**From:** Anita Gardner <Anita.Gardner@arun.gov.uk>  
**Sent:** 04 November 2021 11:59  
**To:** Planning.Responses <Planning.Responses@arun.gov.uk>  
**Subject:** FW: Planning Consultation on: WA/91/21/DOC

Engineers Comments Regarding Surface Water Drainage

The surface water drainage design and supporting information does not meet our requirements and as such I cannot recommend that Condition 12 is discharged at this time. The following areas need clarification/addressing. I am happy to provide one further consultation if further information can be provided within your deadline.

Soakaway test results

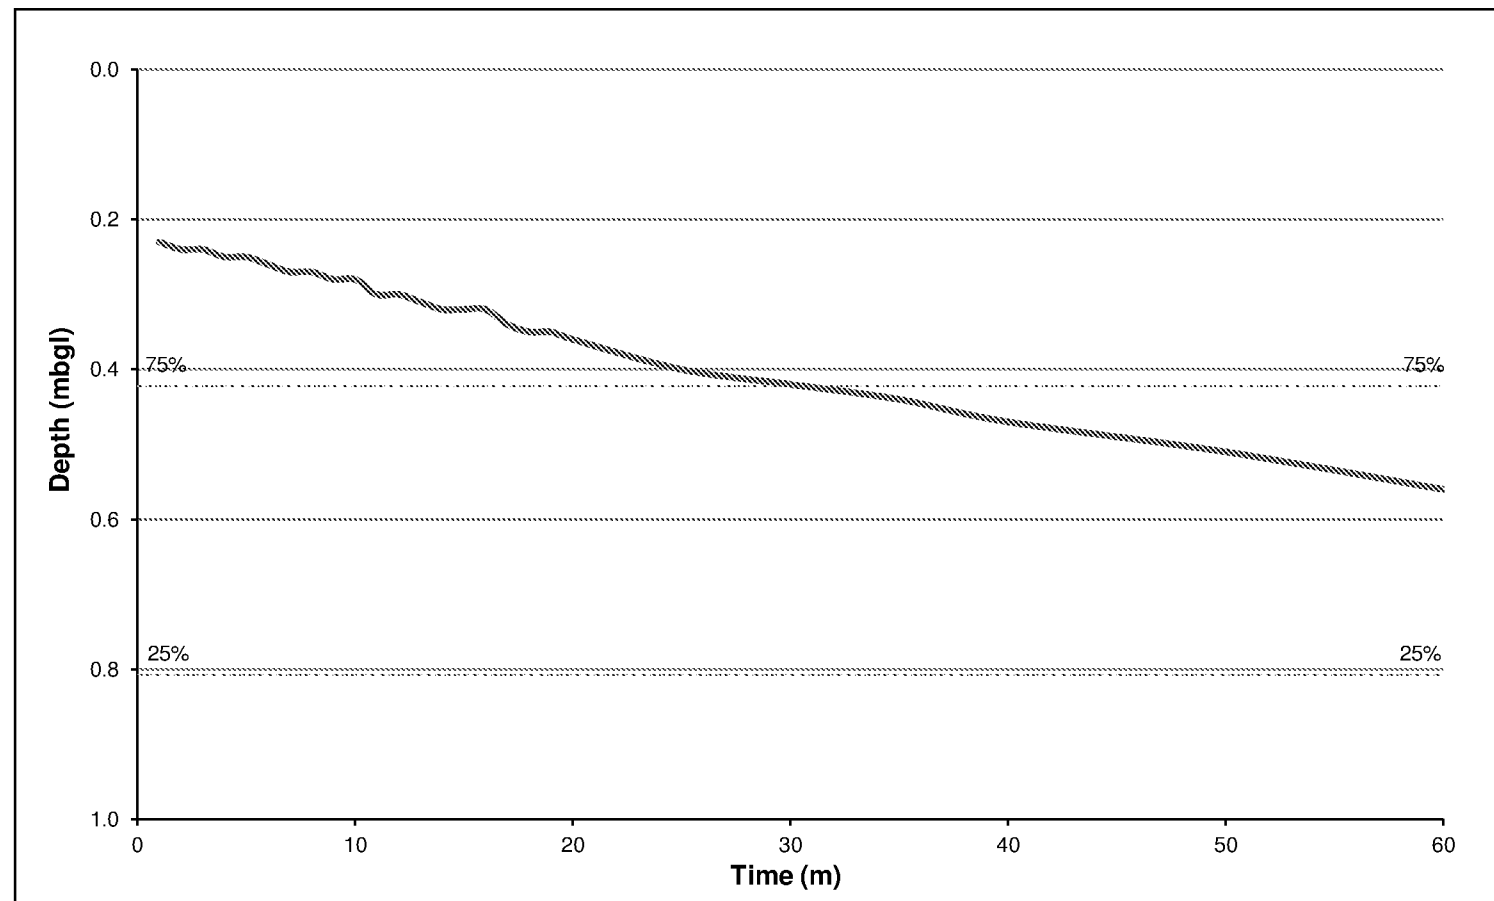
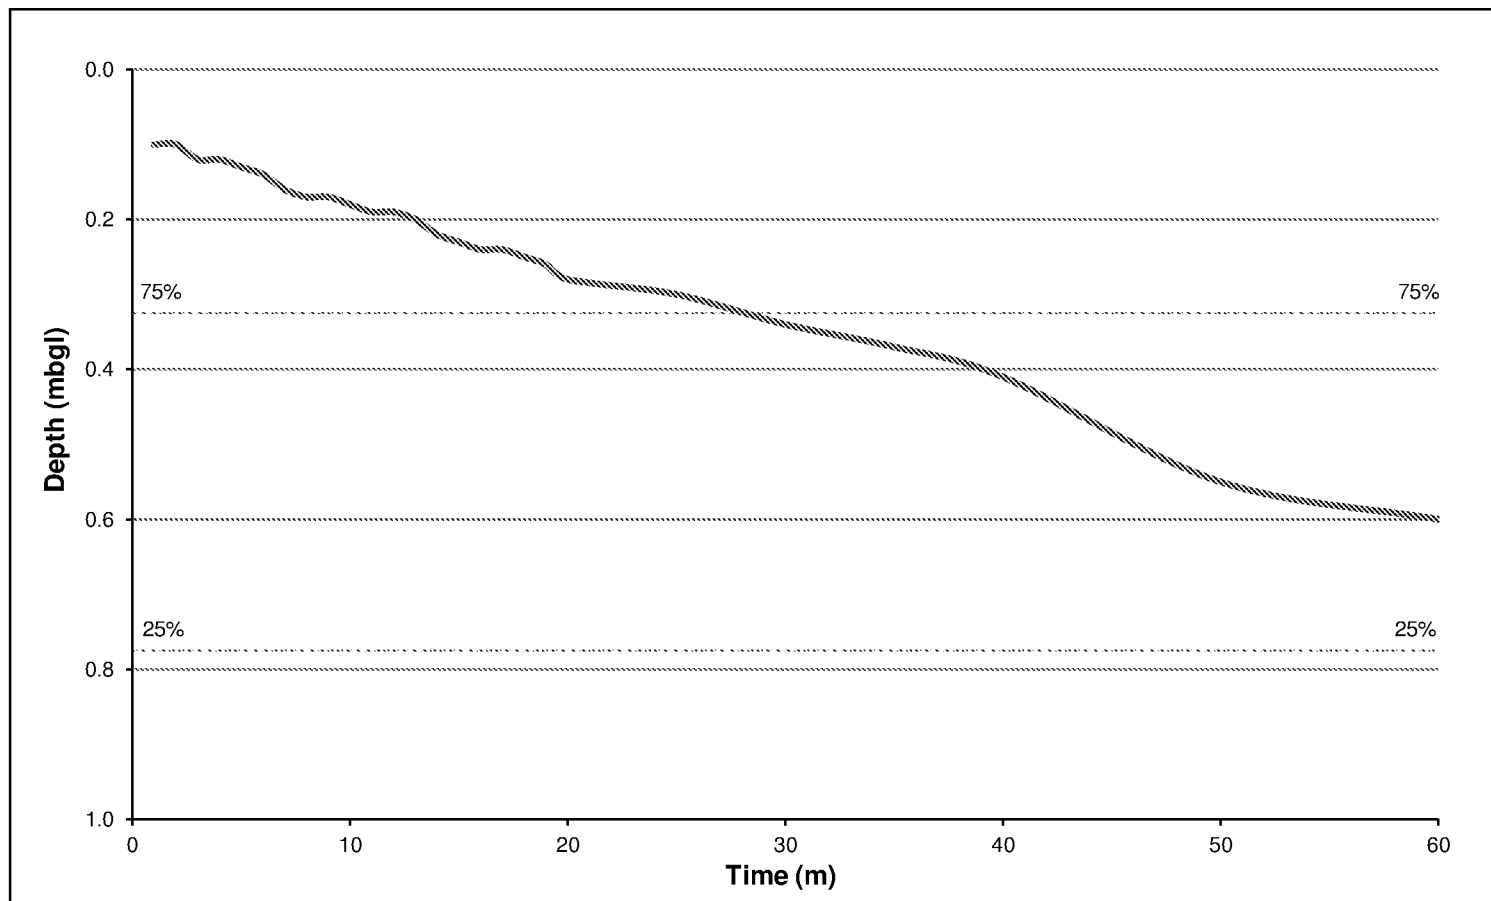
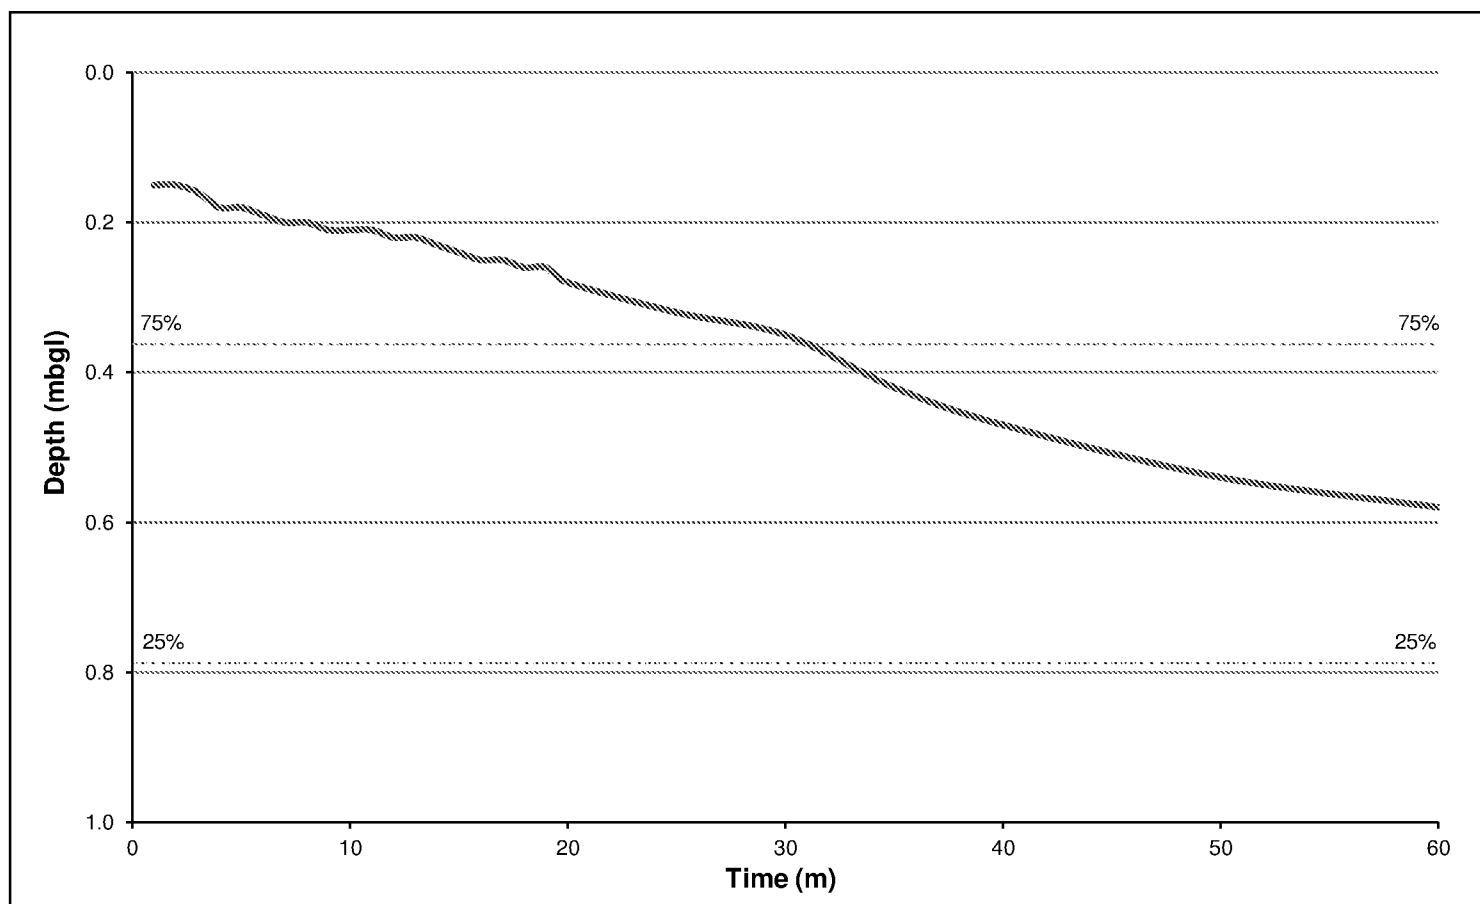
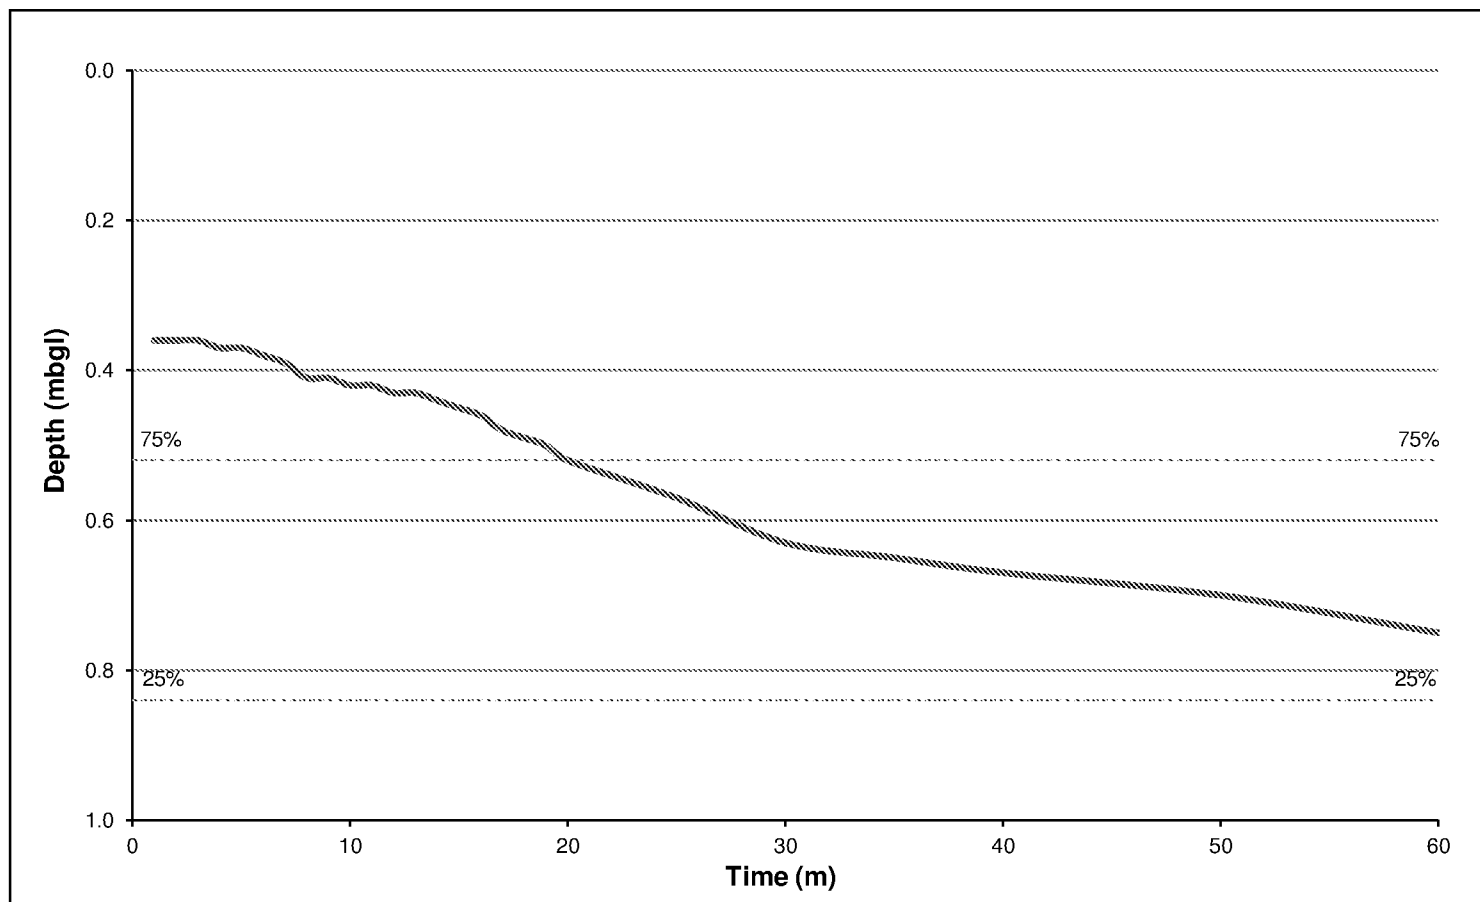
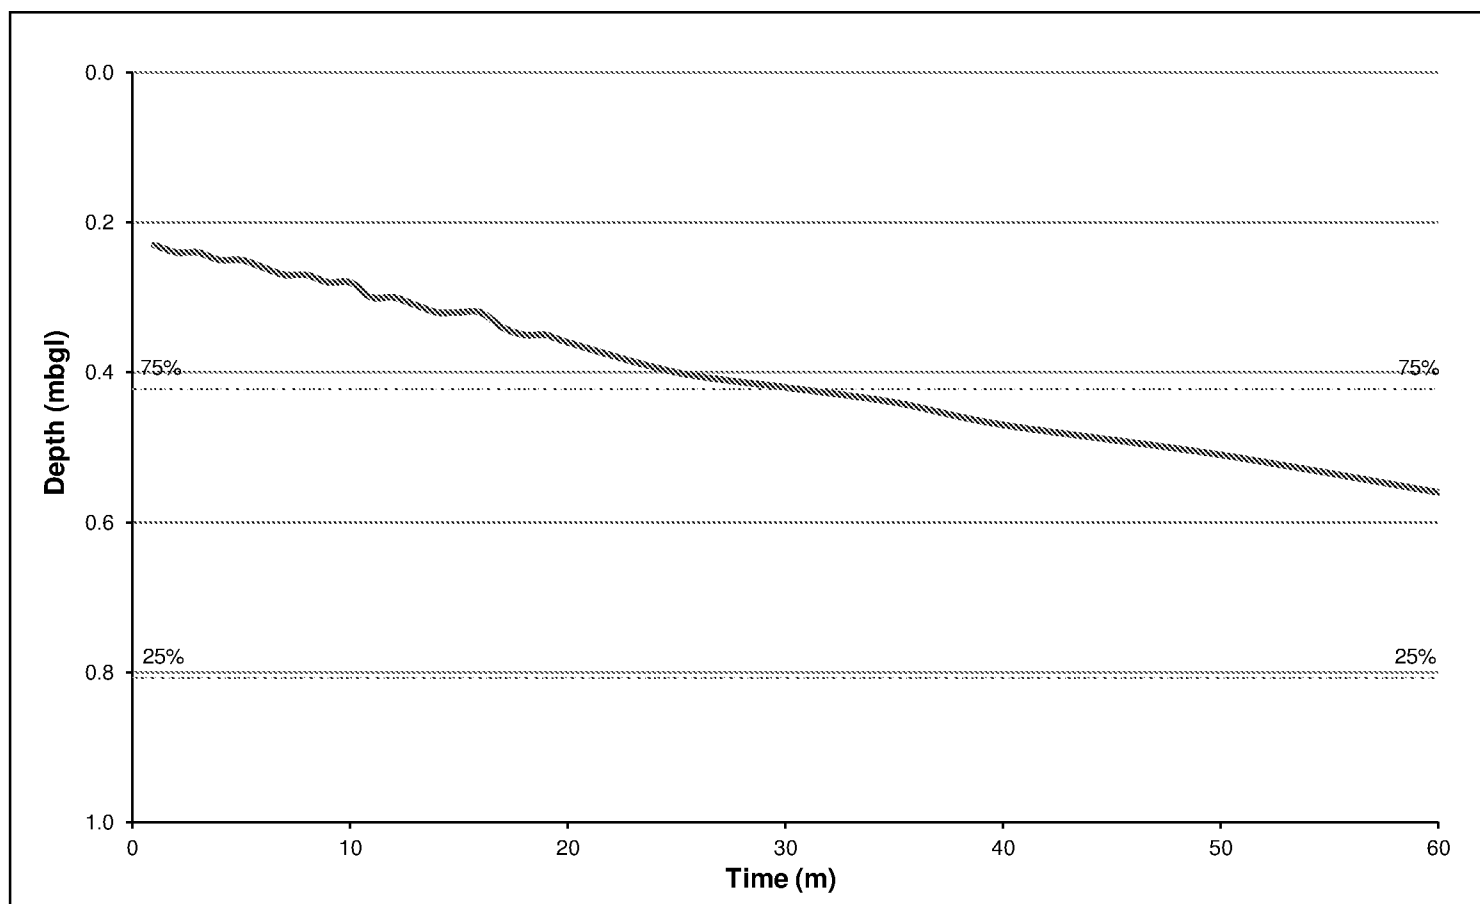
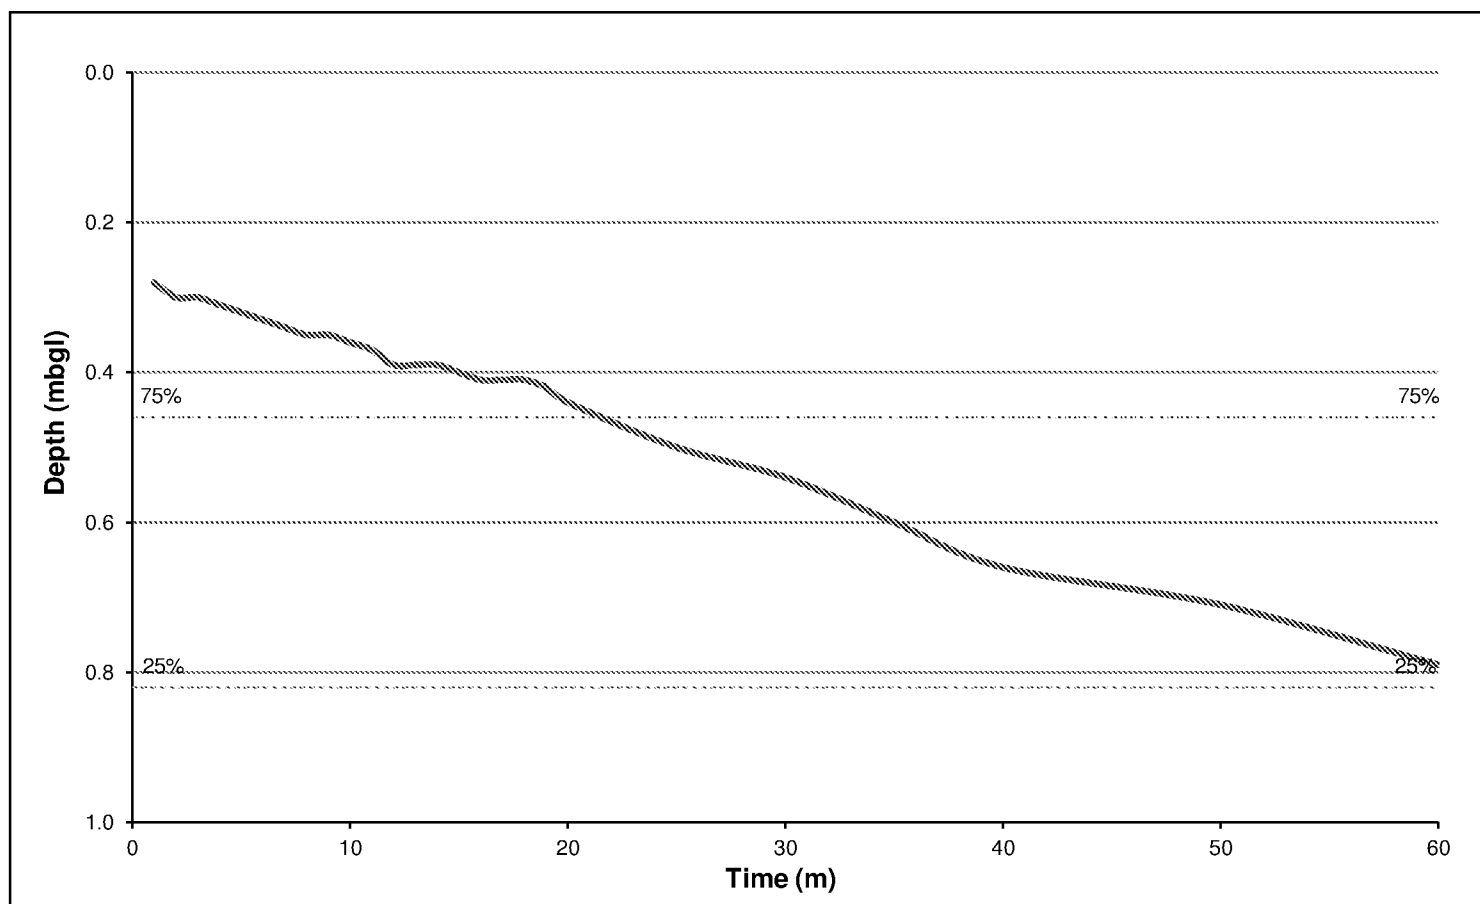
1. Please provide a clear list/table of exactly when and to what depth groundwater was observed.
2. Infiltration testing was only monitored for 60mins for each test after which point the results of almost every test was extrapolated. This is not in strict accordance with BRE DG 365 and no justification is given for the short duration of monitoring. I would like a justification for the methodology and expect a higher factor of safety (of at least 3) to be used in the calculations if these rates are to be used.
